AIR NAVIGATION, AIRSPACE AND AERODROMES BRANCH

CASA Ref: F23/1376-45

PROPOSED MIXED USE MOSTLY RESIDENTIAL BUILDING DEVELOPMENT EASTLAKES SHOPPING CENTRE 19A EVANS AVENUE - CASA COMMENTS

CASA has reviewed the Aviation Impact Assessment (AIA) Report by Thompson GCS of 28 May 2026.

- ASSUMPTIONS TC3 HELPS INCREASE JIB LENGTH OF TC4 TO 50m AND IS TAKEN OUT- TBC
- TC4 GAIN HEIGHTS AND COMPLETE THE ADJACENT BUILDING

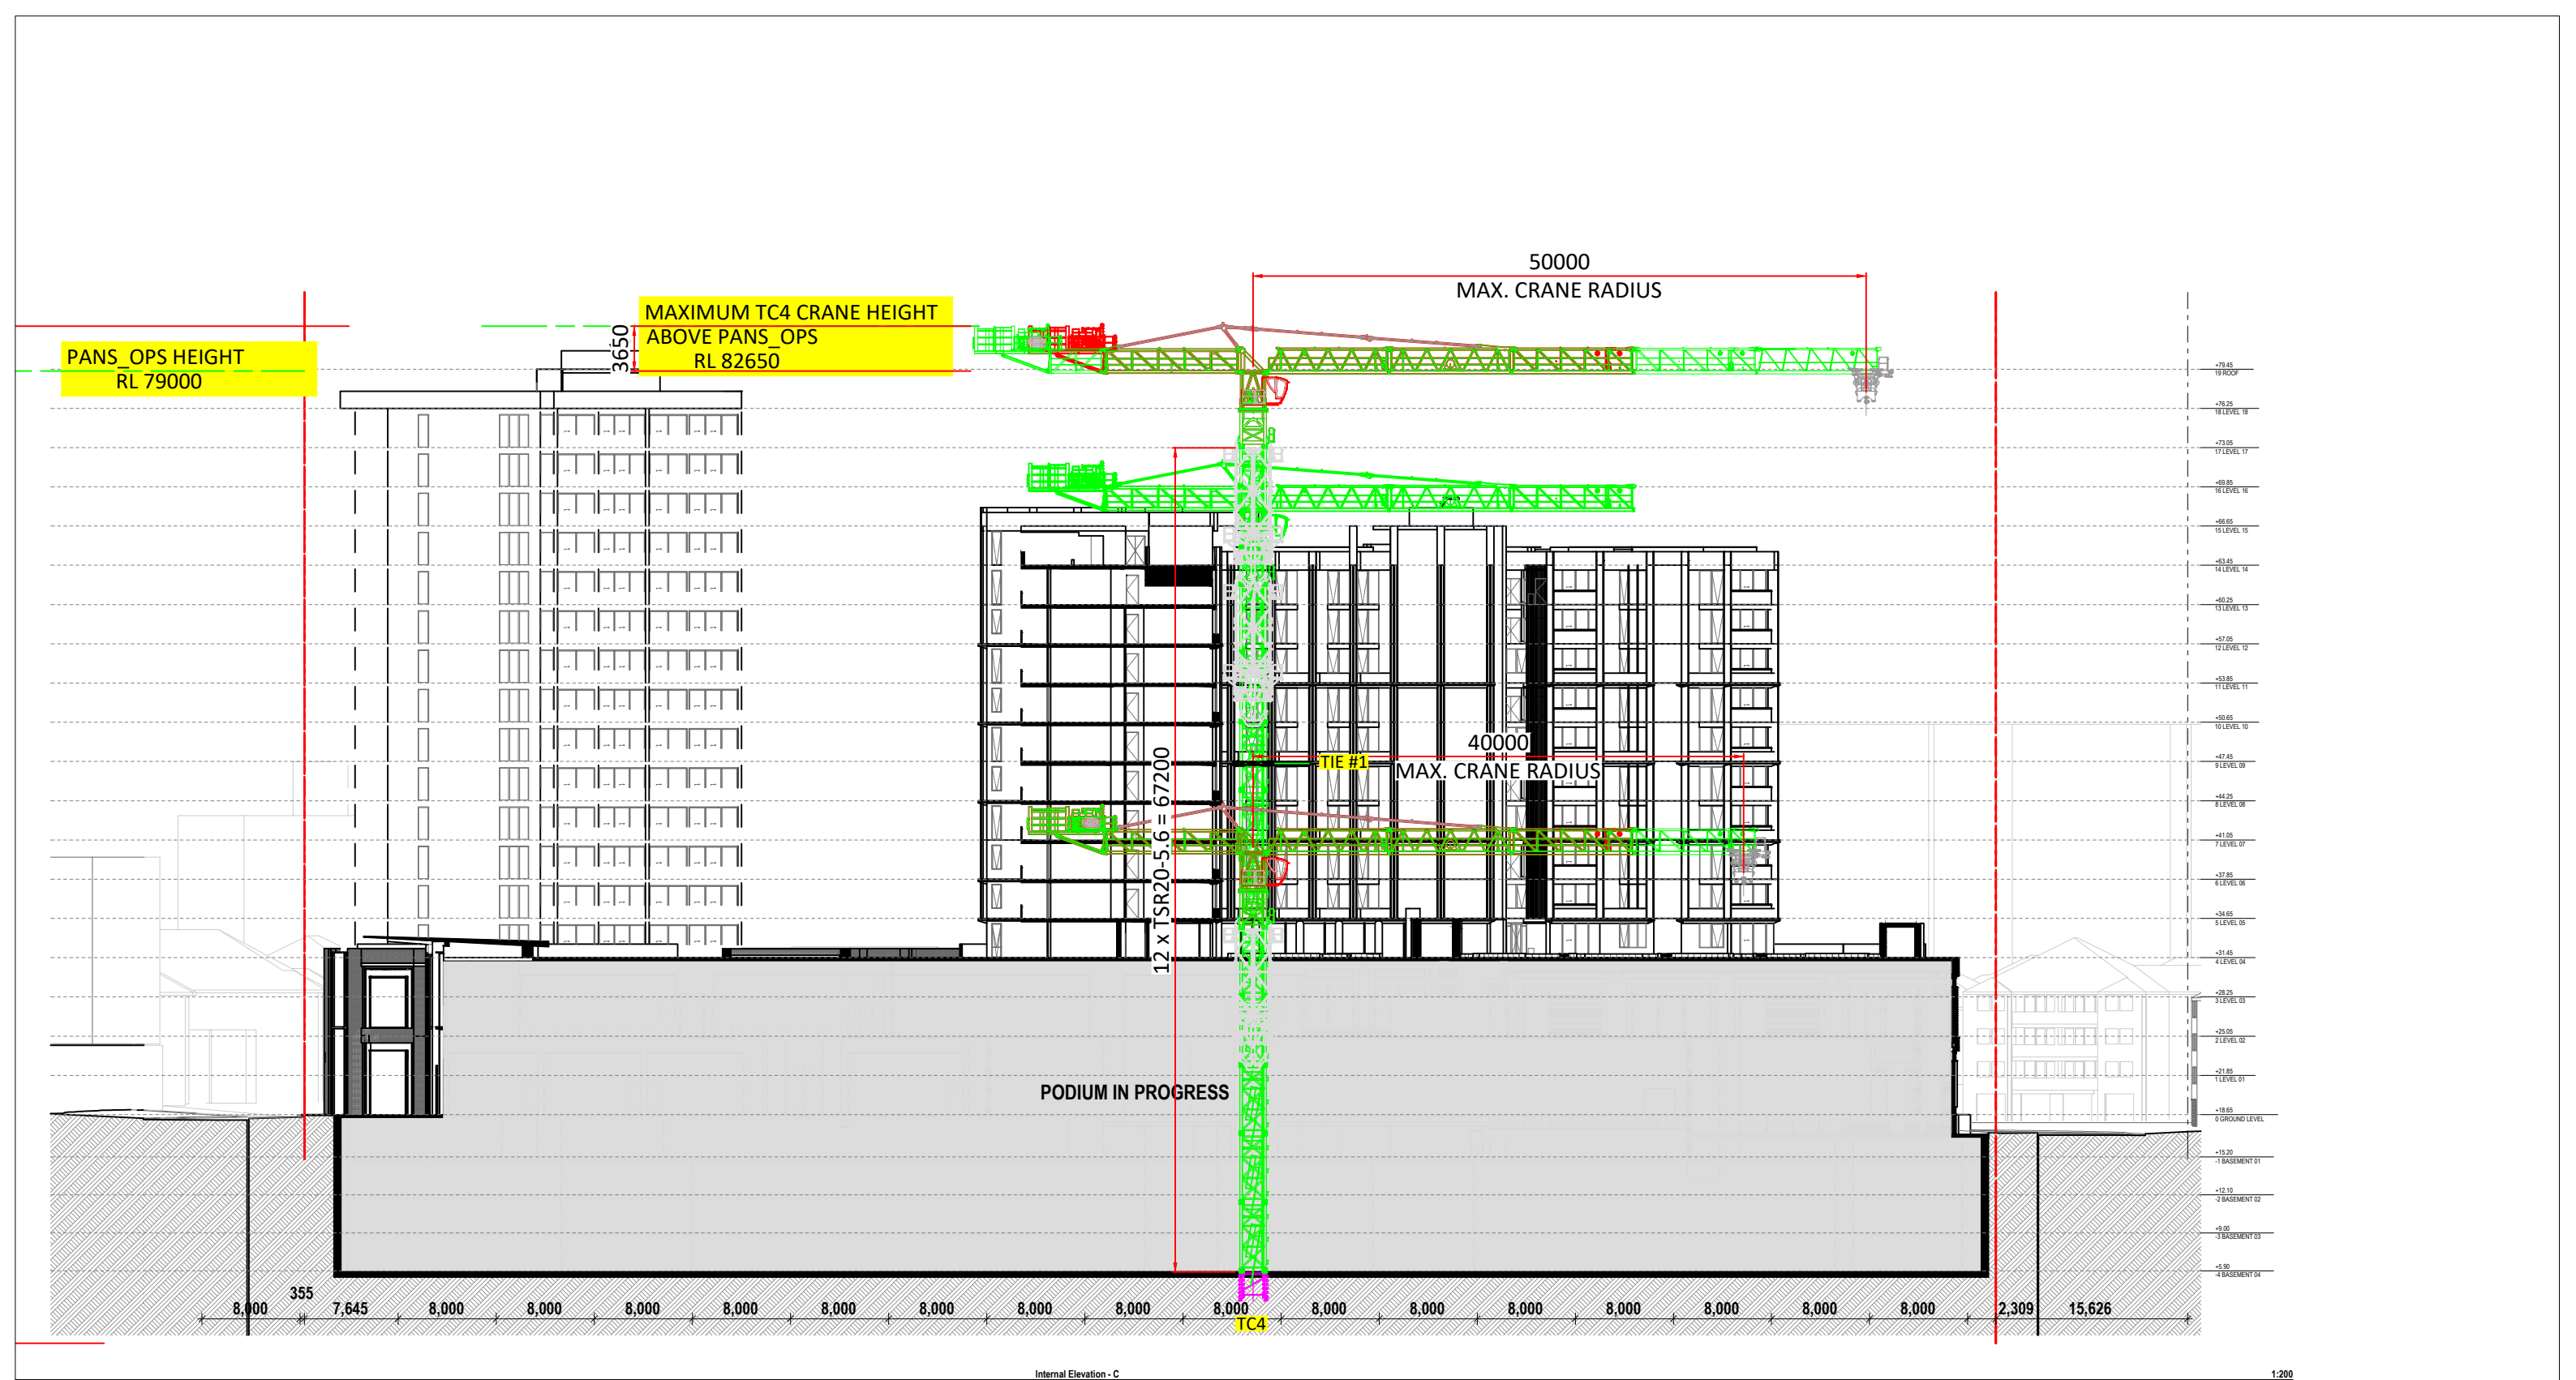
- The Department of Infrastructure will consider each tower crane as a temporary sensitive controlled activity;
- Airservices can mitigate the PANS-OPS / TIFPOP infringements by tower cranes;
- If the mobile crane infringes PANS-OPS / TIFPOP, it can be mitigated by Airservices adjusting IFPs and / or Sydney Airport adjusting runway lengths;
- The buildings can be built safely / in accordance with the Airspace Regulations ...

- the buildings (it is likely that CASA would recommend obstacle lighting on the tallest building noting that the tallest existing buildings in the vicinity are in the order of 9 storeys (and it is close to PANS-OPS).
- the tower cranes (obstacle lighting, obstacle marking, NOTAMs etc - to be finalised)
- the mobile crane(s) (obstacle lighting, obstacle marking, NOTAMs etc - to be finalised)

However, before CASA makes recommendations, CASA will need Airservices' assessment of the buildings and cranes.
